Fwd: Appropriate native plantings for Cliff Island, Maine 04019

Cliff Island property (87 Church Road). A large amount of honeysuckle (invasive) was removed by ACE (a program to remove invasive species) early in the summer, and it is now our responsibility to plant new items in this area. We would appreciate any help you can give us in a timely manner.

RESTORATION PLAN

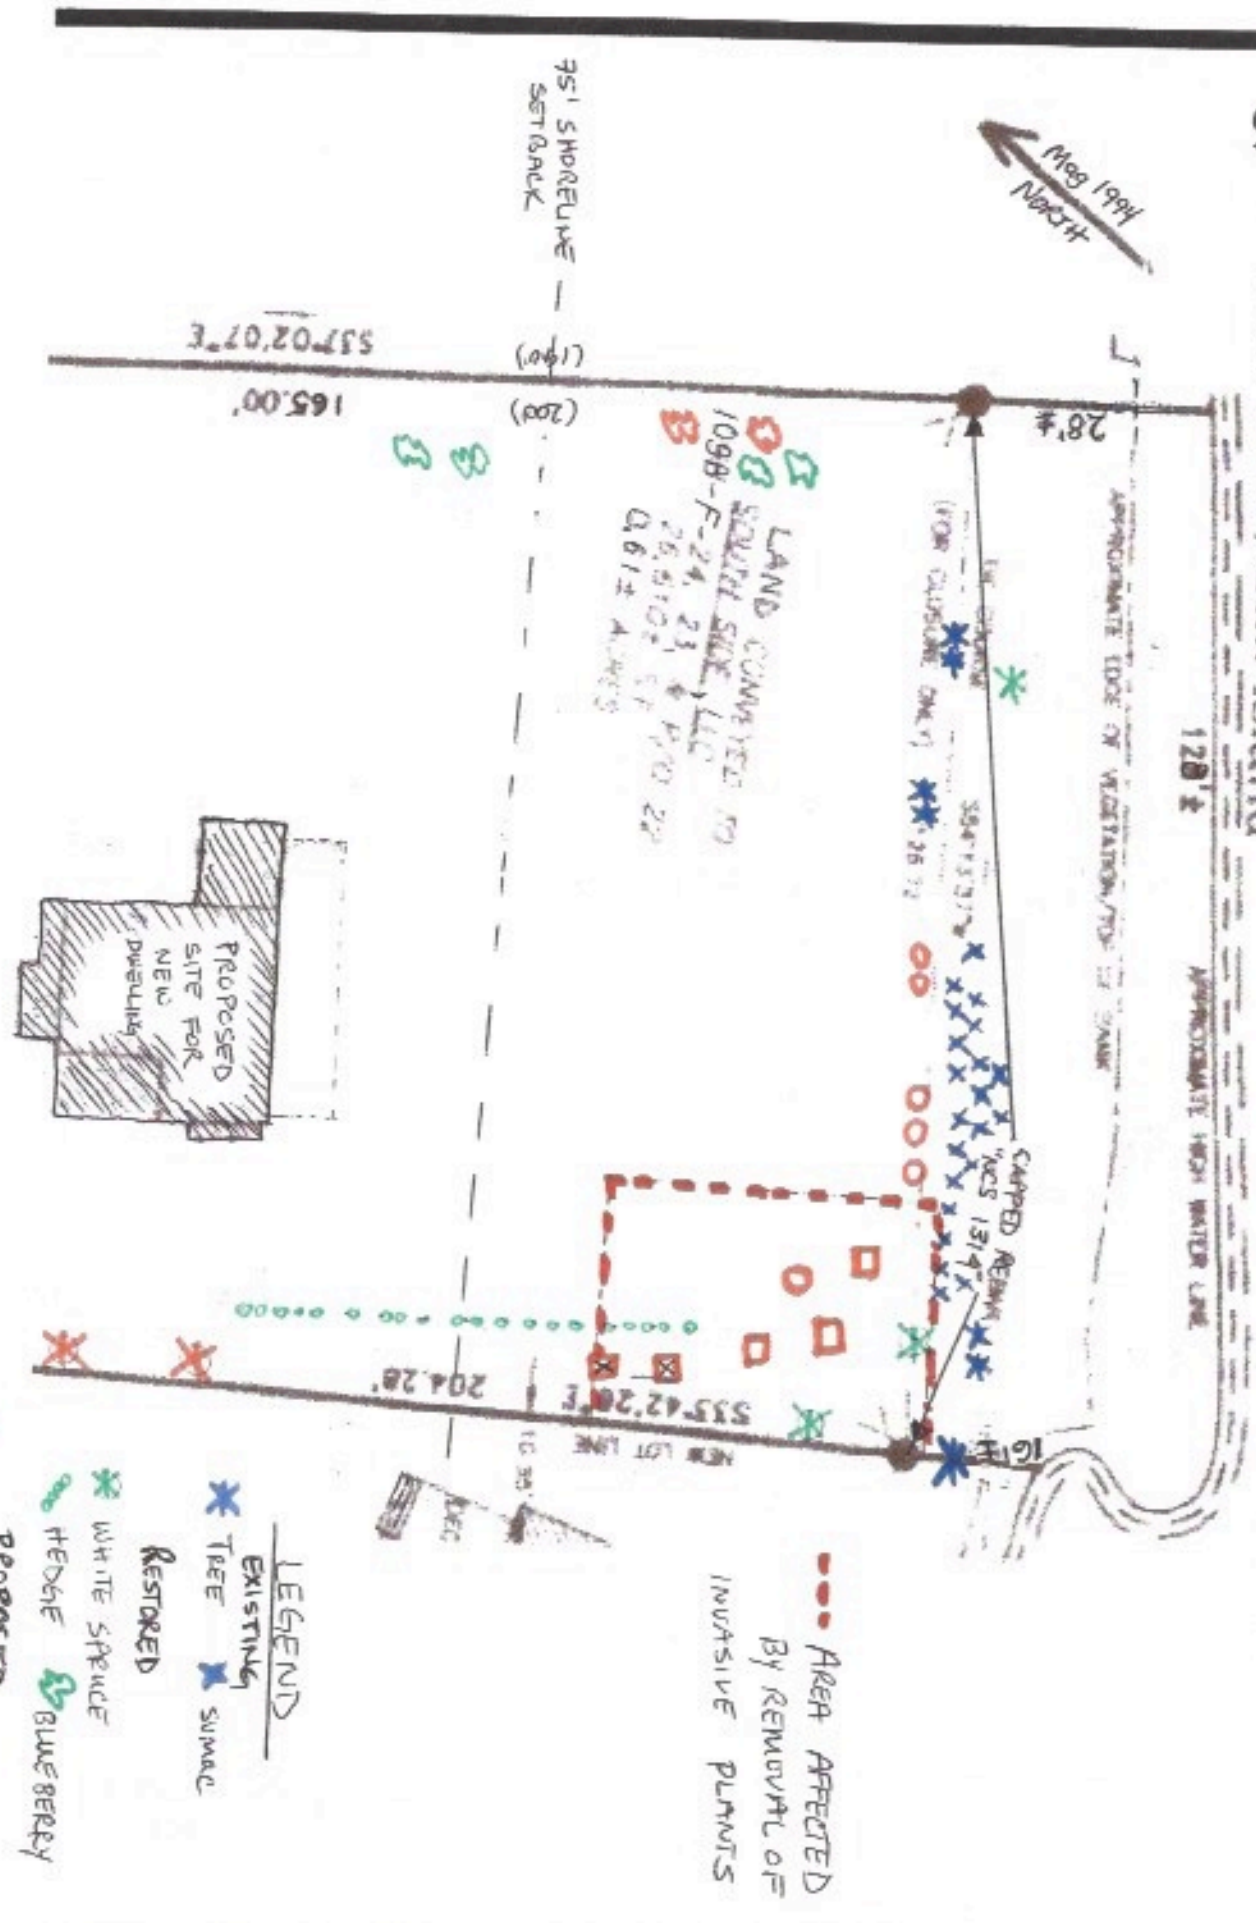
Regarding native plantings, I do not recommend any cultivar of *Rosa rugosa* as this is not native and is known to be invasive in coastal habitats. Blueberries may or may not survive depending on the site but bayberry, sweetfern, and/or beach plum could be good choices in dry or shallow soils. I attach a publication from Cape Cod which lists several good choices for coastal environments (first table, note species marked with star are particularly tolerant).
